NC DEPARTMENT OF
**HEALTH AND
HUMAN SERVICES**

July 22, 2024

RE: Jersey Mike's Subs
NC Hwy 210
Lillington, NC 28546

This letter acknowledges review of the plan for the above referenced establishment. The revised plans dated 07/16/24, application and email correspondence are approved with the following conditions:

4 TANKLESS WATER HEATERS
 P1.3 SCALE: NONE

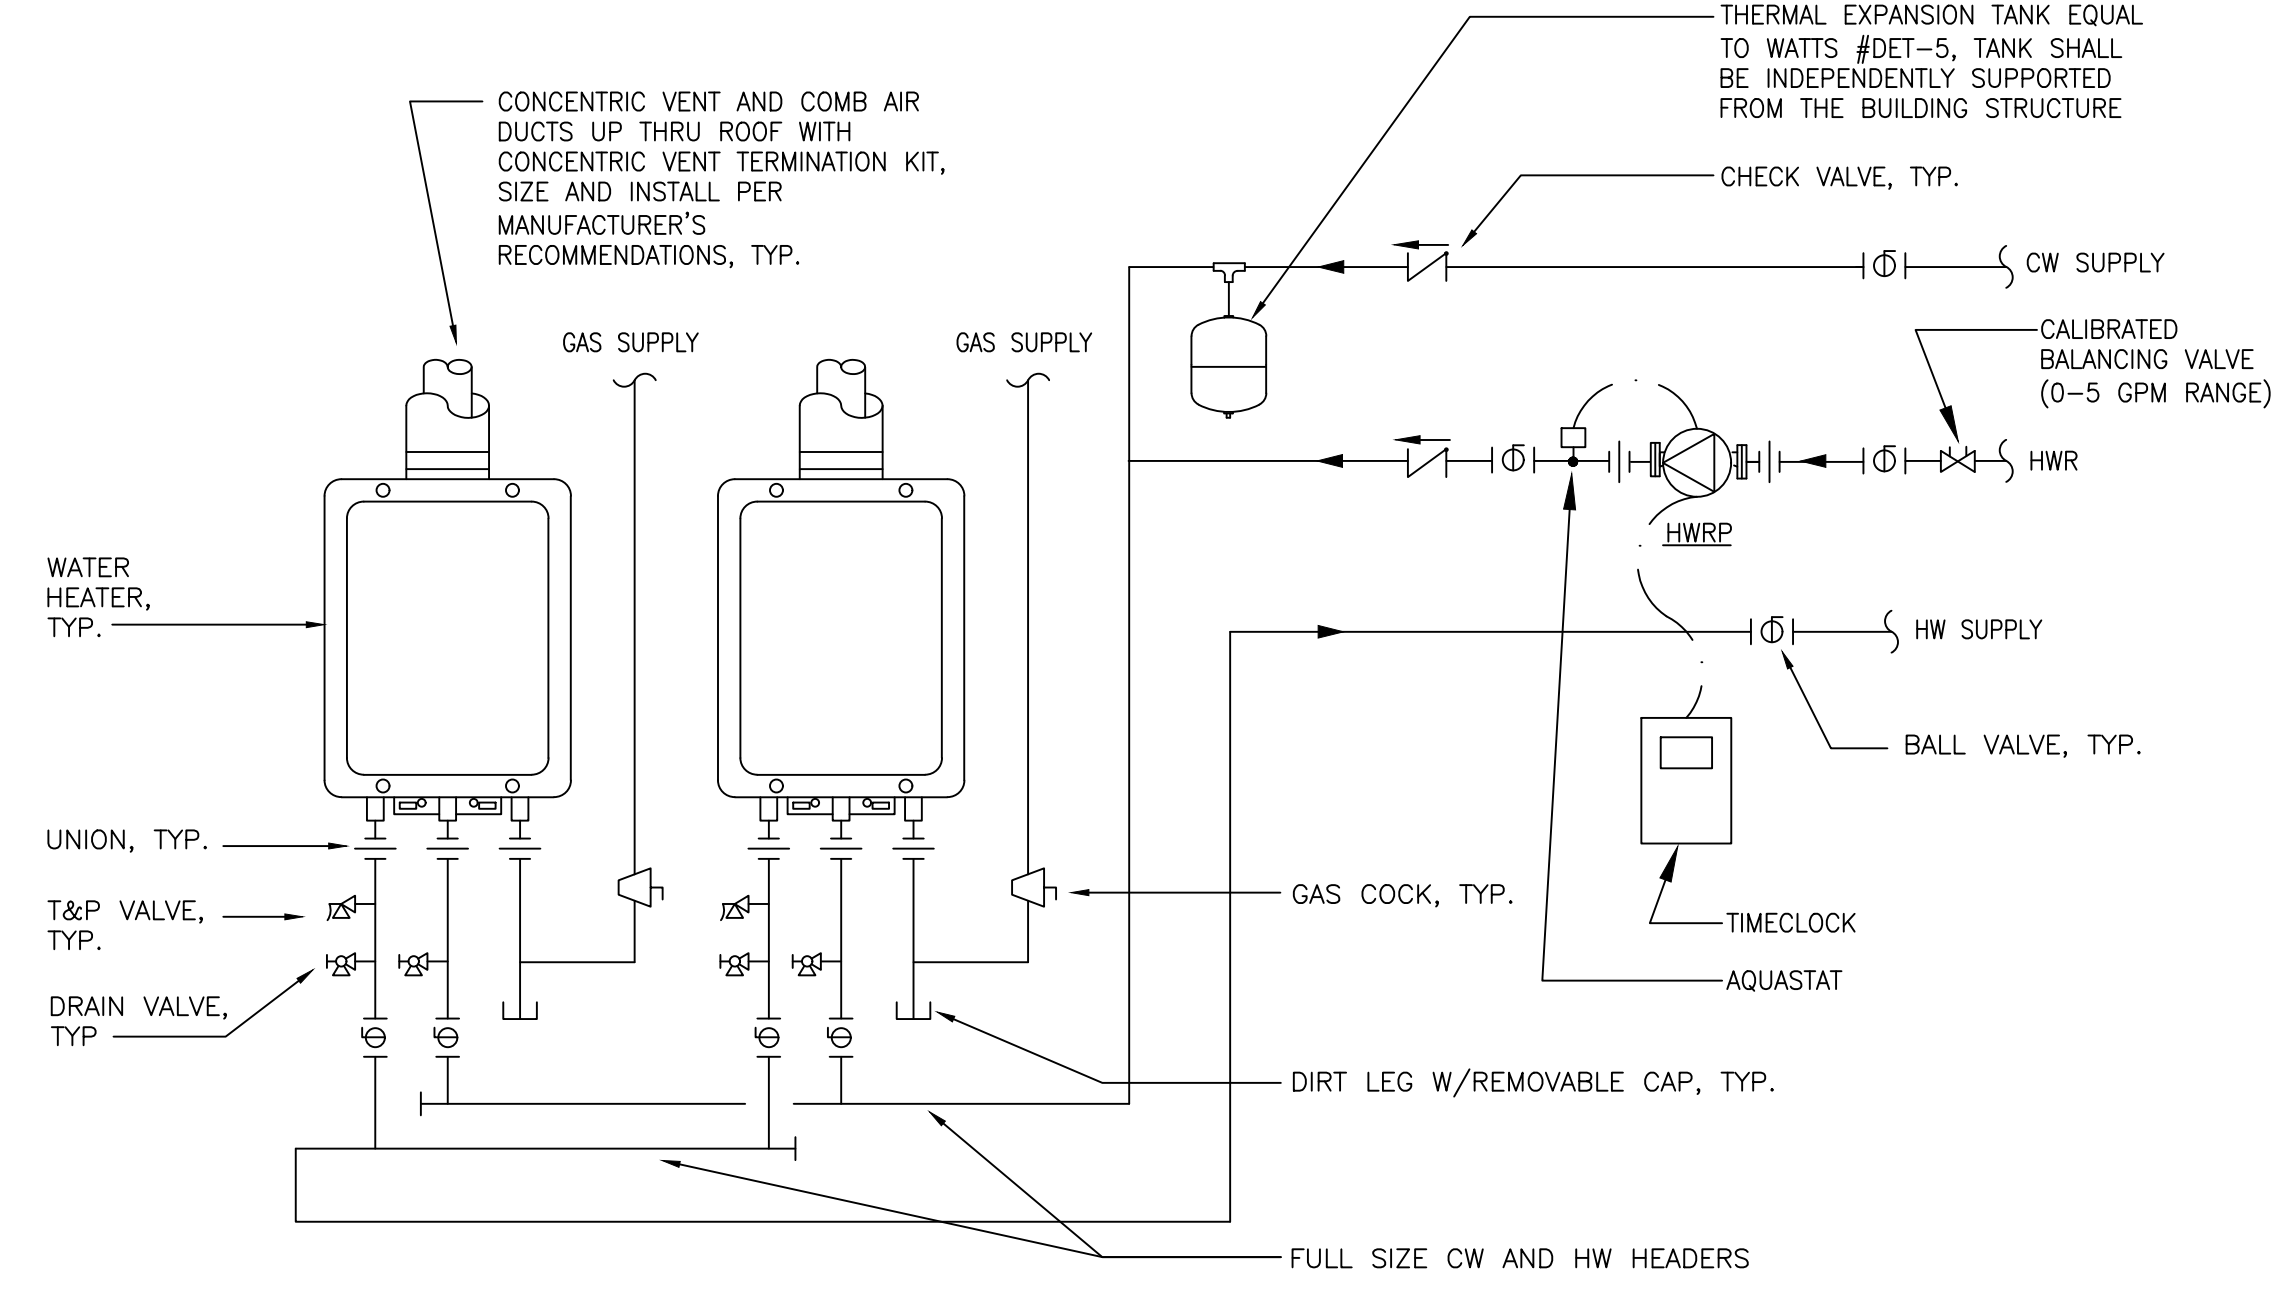
4. The plumbing, water and waste plans must comply with Parts 5-1 and 5-2 and Parts 6-1, 6-4 and 6-5 of the NC Food Code. The two 199,000 BTU tankless water heaters specified on the application and sheets P1.1, P1.2 are approved provided they provide sufficient hot water to all parts of the establishment. All exposed parts of the tankless water heater(s) should be installed so they are smooth, non-absorbent, and easy to clean.
